From: Holland Architecture [REDACTED]
Sent: 19 December 2019 09:26
To: Zac Denton <Zac.Denton@arun.gov.uk>
[REDACTED]
Subject: RE: AB/115/19/DOC

AB/115/19/DOC

PROPOSED MANSARD VENTILATION

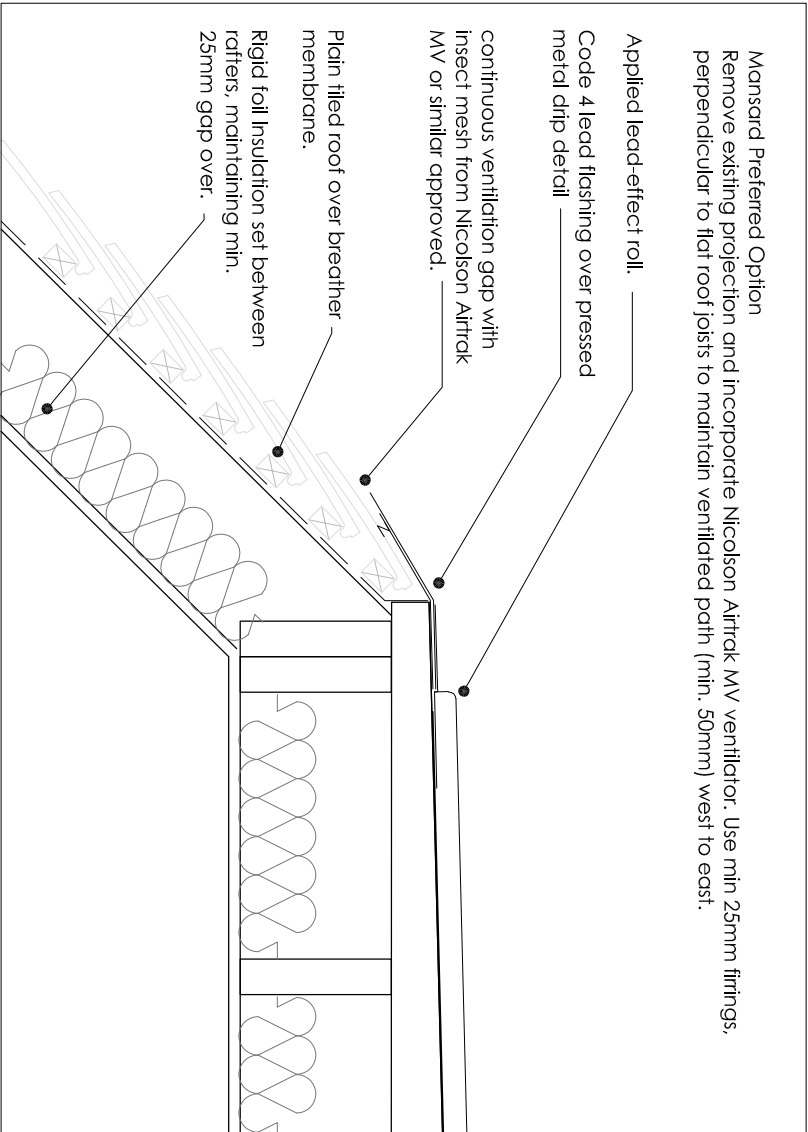
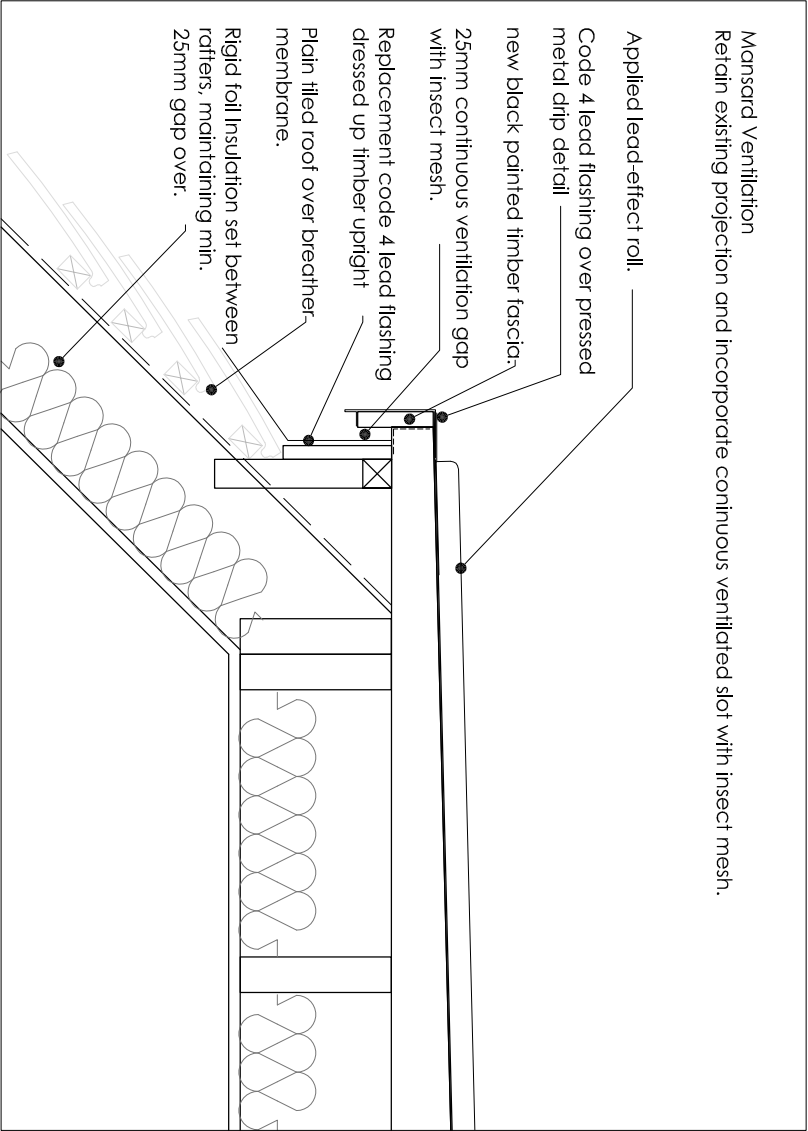
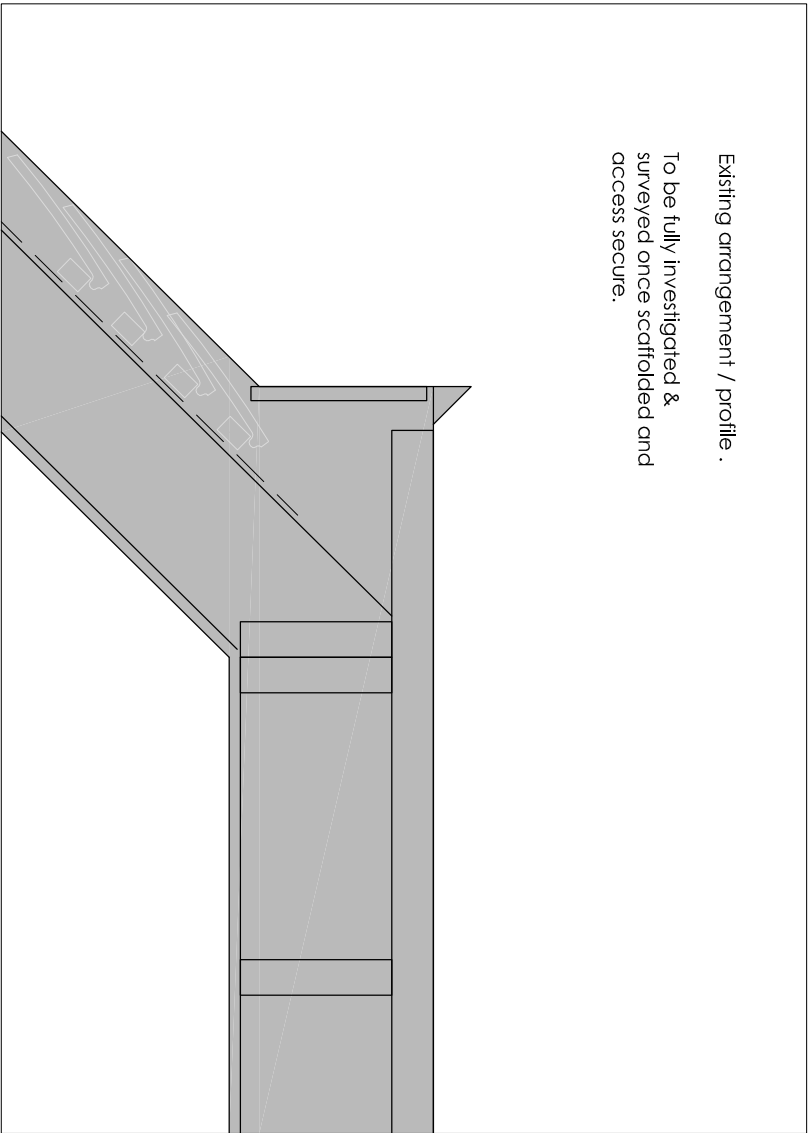
1. With regard to the roof covering/mansard detailing, it is thought that both are o.k., especially the preferred approach. This will depend upon the approach taken by the neighbour. It is suggested that the architect could keep us informed of the final choice?
2. This is still of concern to me, as I would not want to see the bricks further damaged, and the options proposed could do that. As a consequence, without evidence to prove that the machinery would not harm the bricks, this approach cannot be supported. It might be that there is a trial sample which we can inspect, prior to the submission of a separate DOC application. However, it might be after the trial that the proposed method of mechanical tools are still not looked upon favourably.
3. The colours seems to be acceptable – do you want to see the specific colours?

- I note that two options re provided regarding the work to the mansard roof, and I believe that the applicants preferred approach is also mine. This is based on the fact that it is more discrete. It is assumed that the structure would still be able to breath and meet the various building regulations.
- Reference is made to the use of machinery for removing existing pointing etc. whilst it is noted that this is subject to conditions such as sample tests and experienced contractors, this is of concern – I work on the principal that hand tools cause less damage and are therefore more suitable.
- Is the colour of the external joinery to match the existing – I can't see any references to this in the application.

- Although our preferred option is for the reduction of the projection feature on the mansard, as it is a detail shared with the neighbouring property at Studio Cottage, it is not yet known if it is capable of being changed and is subject to investigation of the existing structure. We have been in talks with the neighbour who is contemplating having their side of the roof recovered at the same time and if so, likely by the same contractor. As we will be insulating between rafters to form a cold roof, we would be maintaining cross ventilation to this roof structure in accordance with Building Control.
